# OXFORDSHIRE COUNTY COUNCIL'S RESPONSE TO CONSULTATION ON THE FOLLOWING DEVELOPMENT PROPOSAL

**Application no:** 22/03064/OUT

**Proposal:** Outline planning application for up to 176 dwellings and associated open space with all matters reserved other than access

**Location:** Land Opposite Hanwell Fields Recreation Adj To, Dukes Meadow Drive, Banbury

Appendix H
Proposed Access
MAC drawing no. 802-TA10A

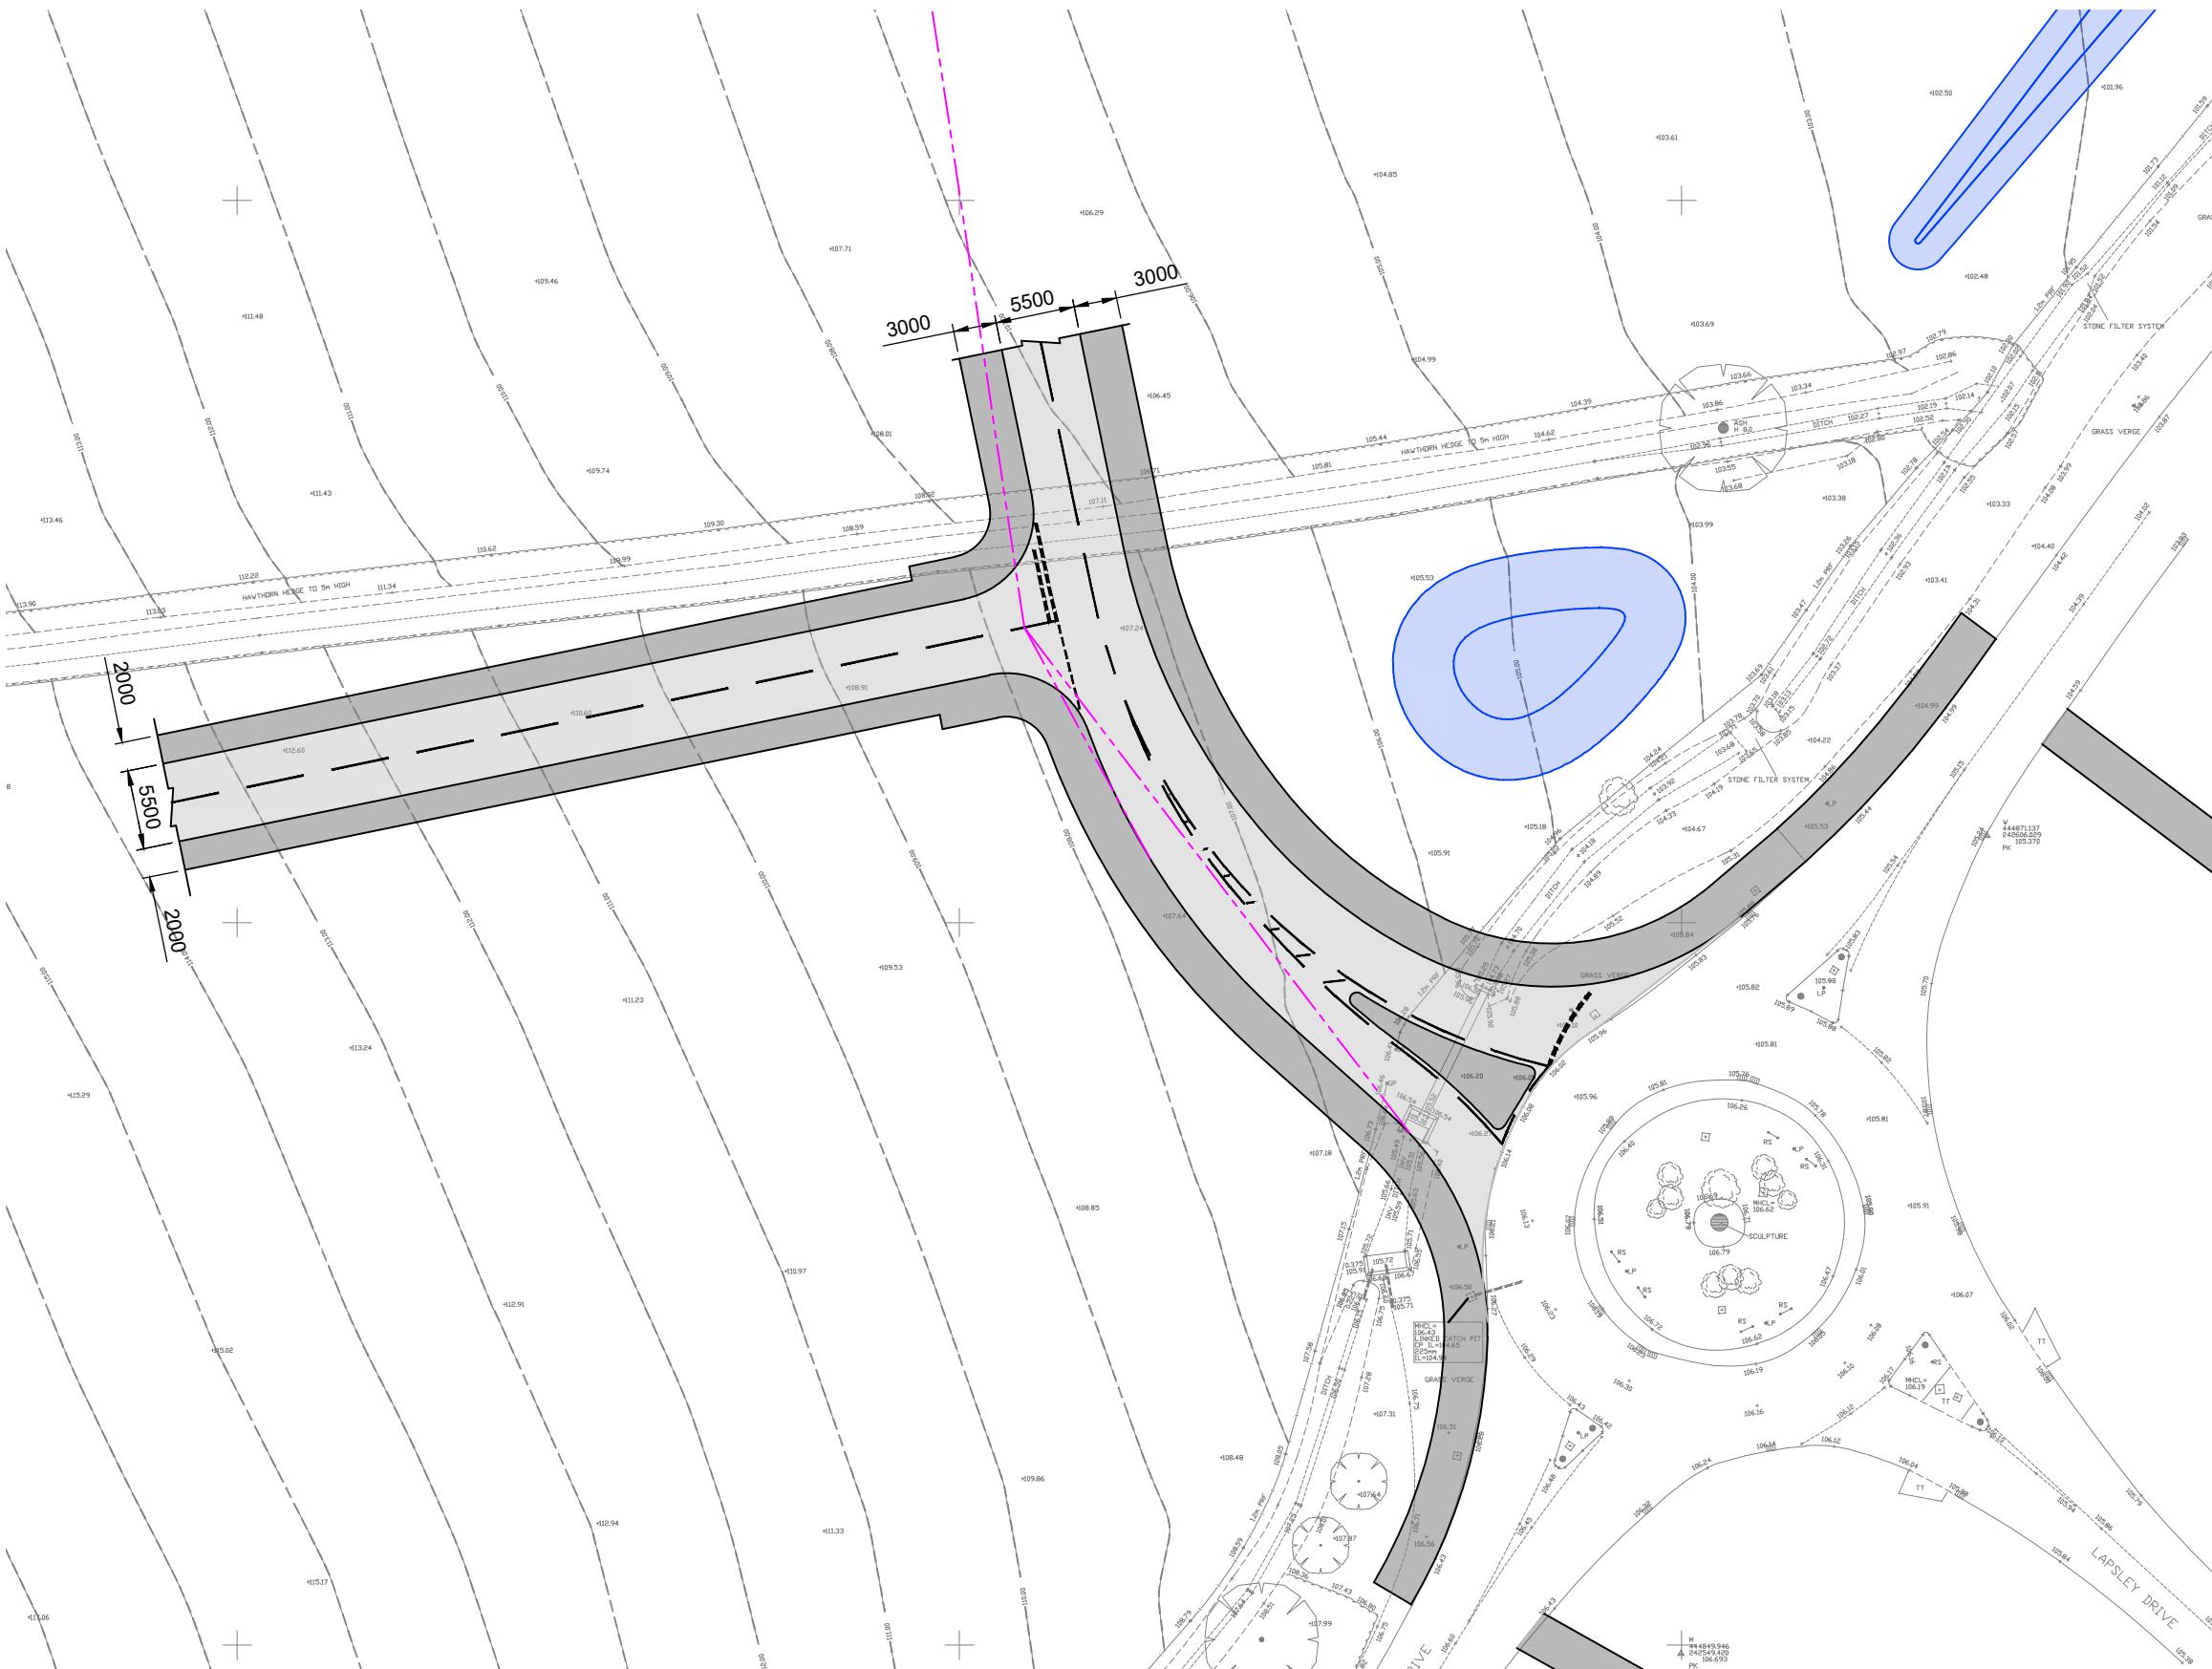
The proposed development will be accessed via a fourth arm (western arm) of the existing Dukes Meadow Drive/ Lapsley Drive roundabout. Supporting this application is a Transport Assessment (TA) that suggests a realignment that would render access from Phase 1 to be the minor arm of a simple priority junction. This is acceptable in principle subject to an updated junction capacity assessment.
